**STAGE 1 ROAD SAFETY AUDIT
REPORT**

Laurclavagh Renewable Energy Project

Laurclavagh Ltd.

March 2024

PROJECT TITLE:			
Laurclavagh Renewable Energy Development, Co. Galway			
DRAWING TITLE:			
Proposed access junction off the L-61461			
PROJECT No.:	DRAWING No.:	SCALE:	
210627	210626 - 39	1:1,000 @ A3	
DRAWN BY:	CHECKED BY:	DATE:	REVISION.:
JOB	TH	13.03.2024	P01

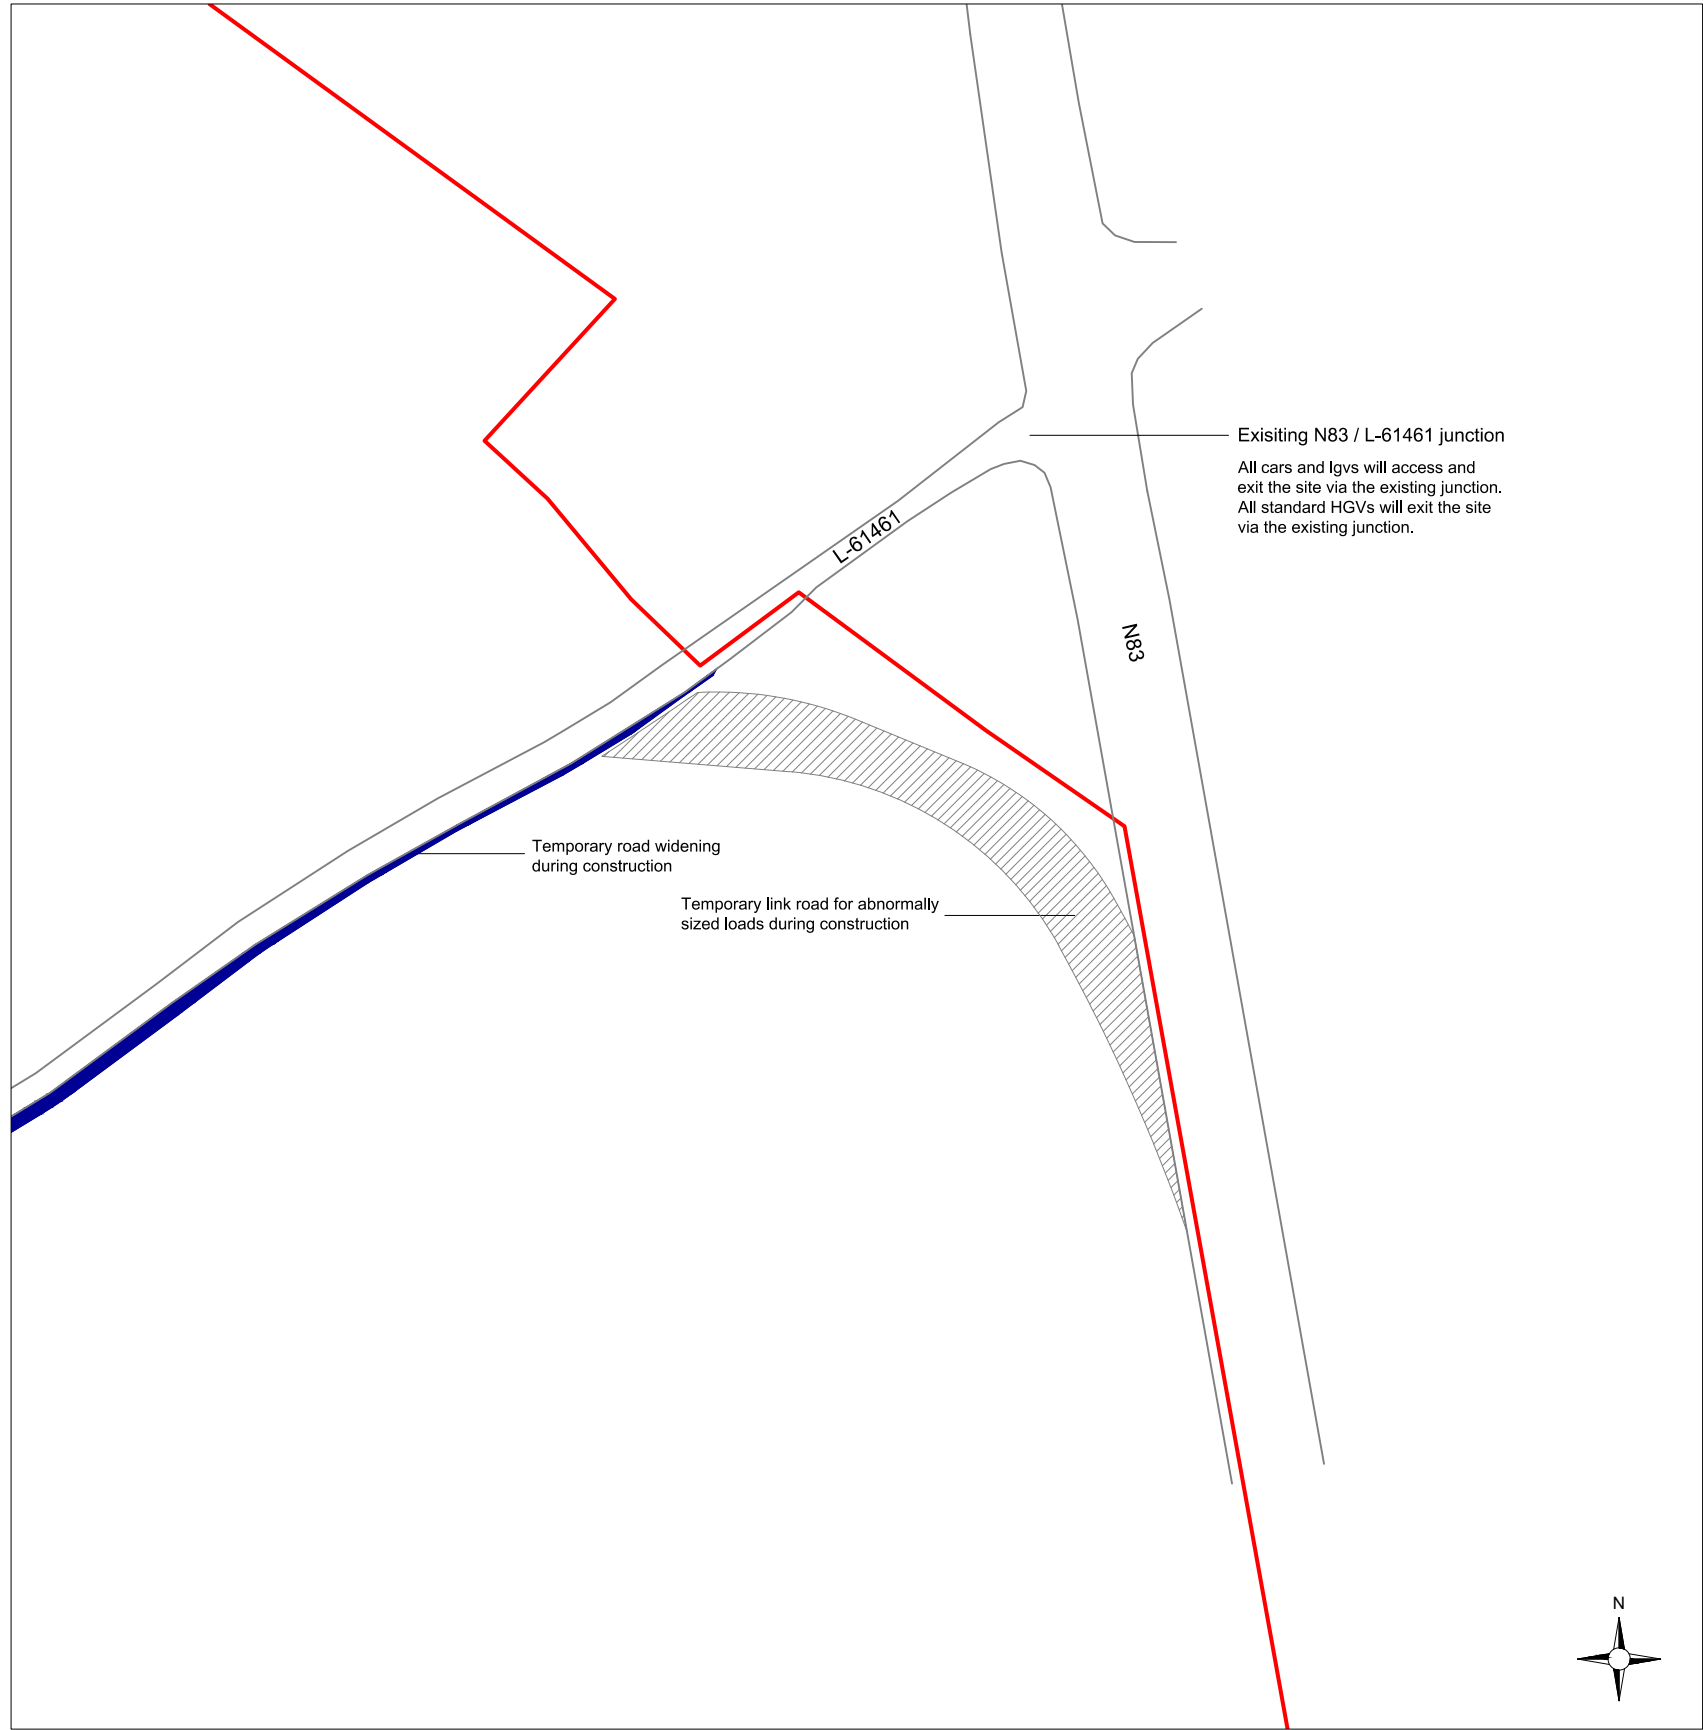
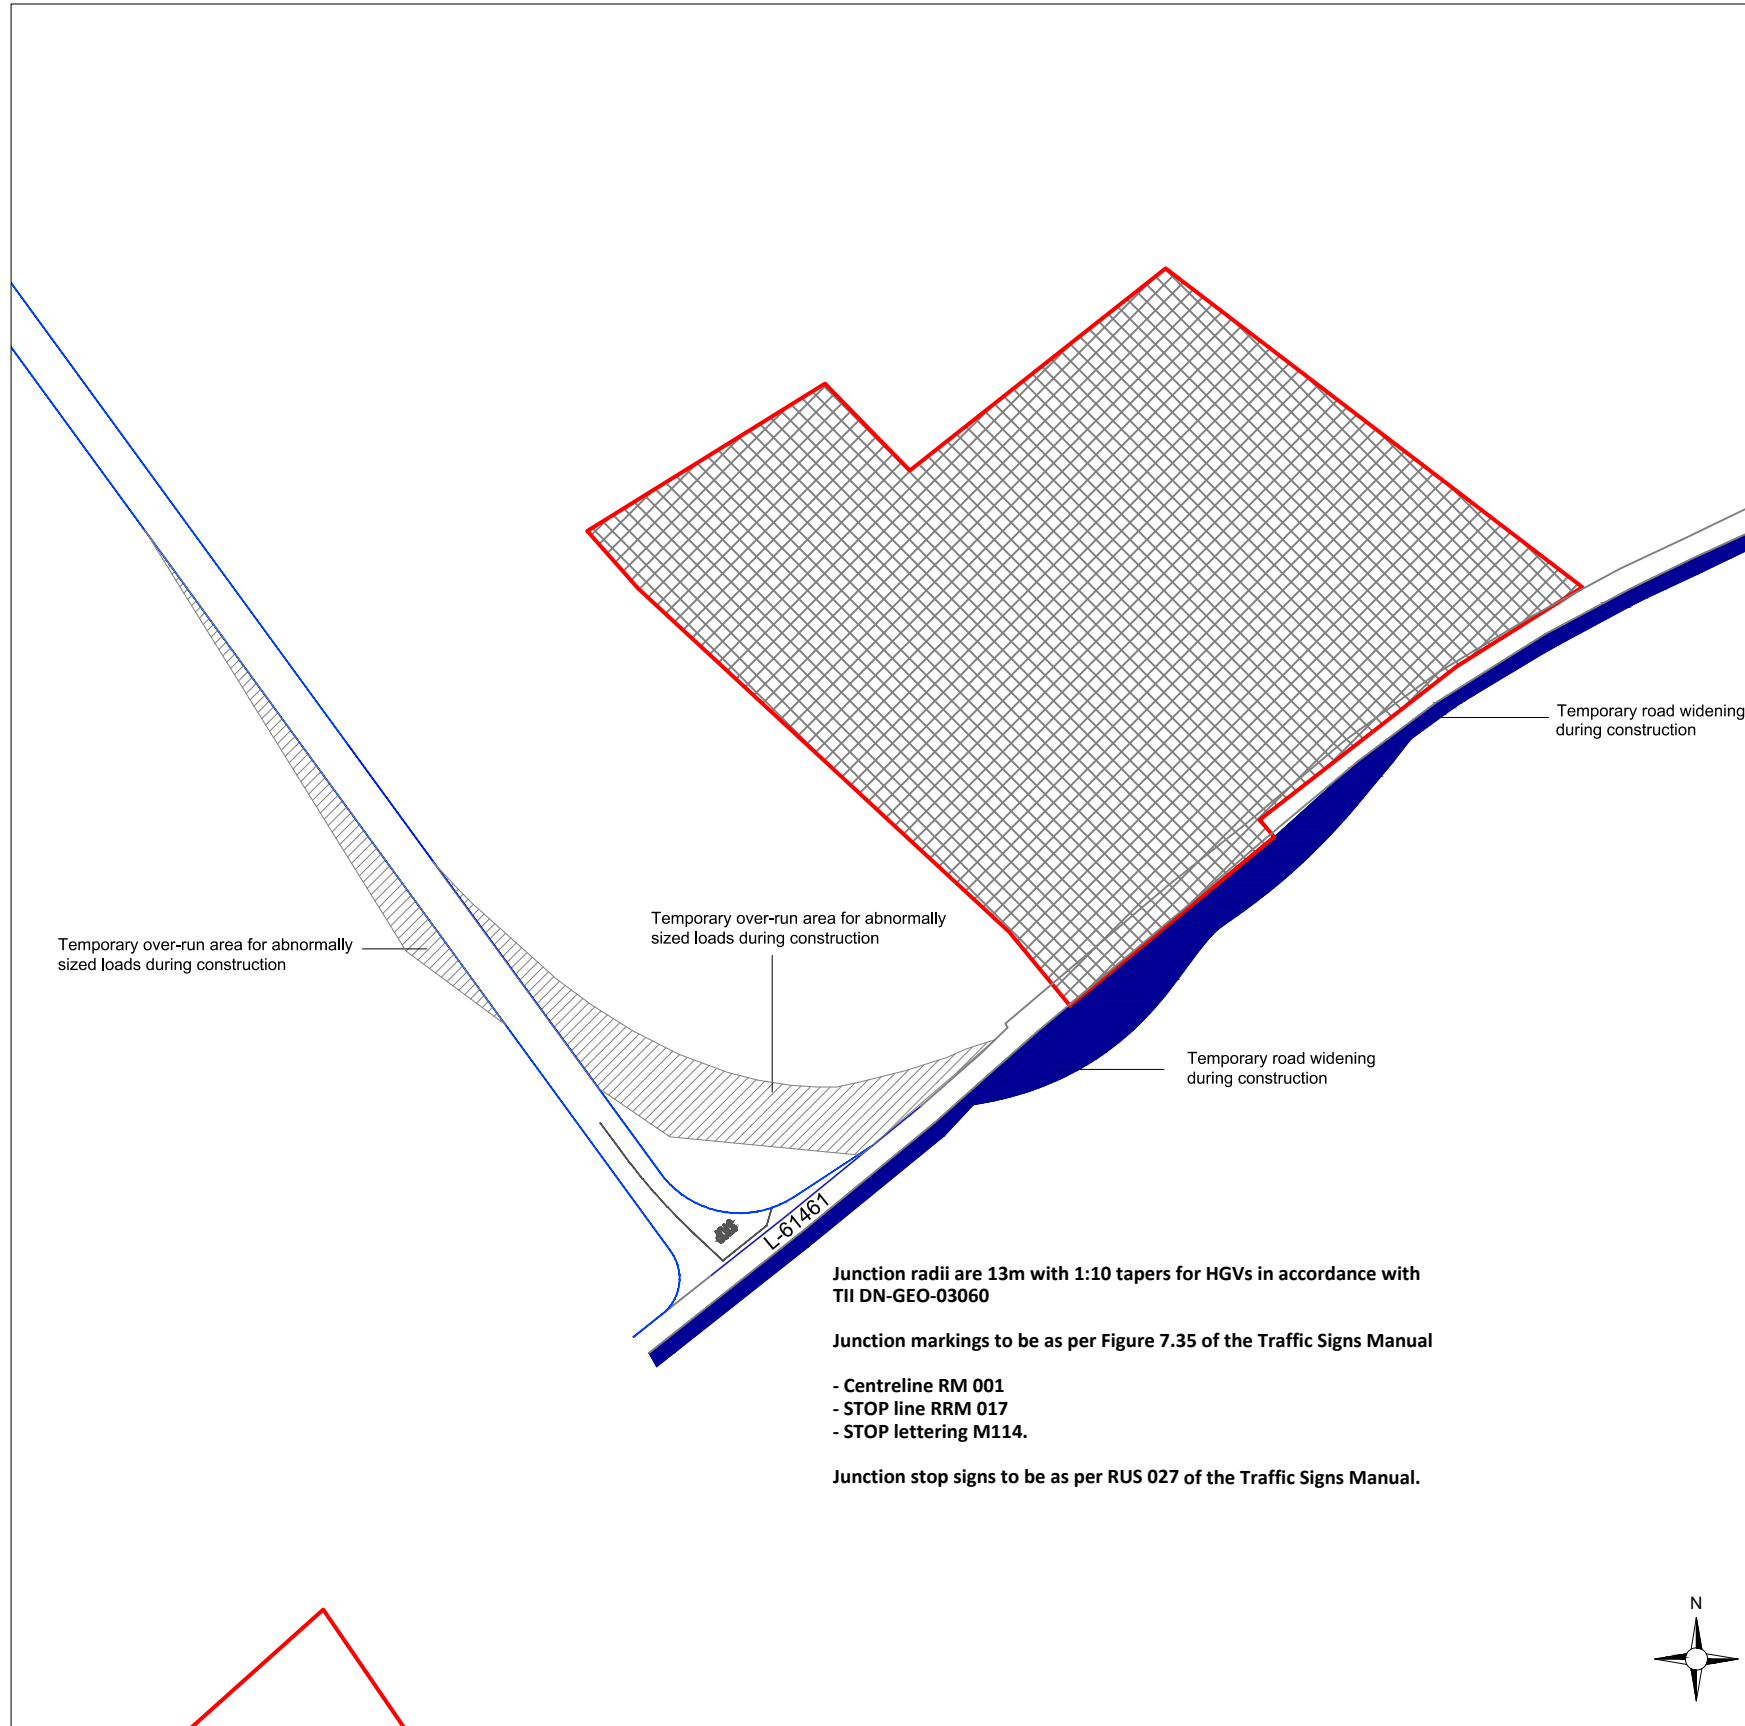
The opening of the over-run area for abnormal loads and construction traffic could create driver confusion, leading to errant drivers (i.e. the general public) accessing the windfarm construction site in error.

Access to the over-run area should be managed appropriately whilst being used for construction traffic to avoid errant drivers entering the works. Access points 1 and 2 should be closed when not required by construction traffic.

2.2	Yes	Yes	The default for the temporary over-run area connecting the N83 to the L-61461 will be that it will be closed to all traffic by means of gates / fencing. During times when this area is being used for construction traffic the access at both ends will be managed at all times by means of signing and site staff (Flagmen), and during the delivery of the abnormally sized loads, by Garda escort vehicles. On completion of the construction phase the link road will be permanently closed with boundary fencing.
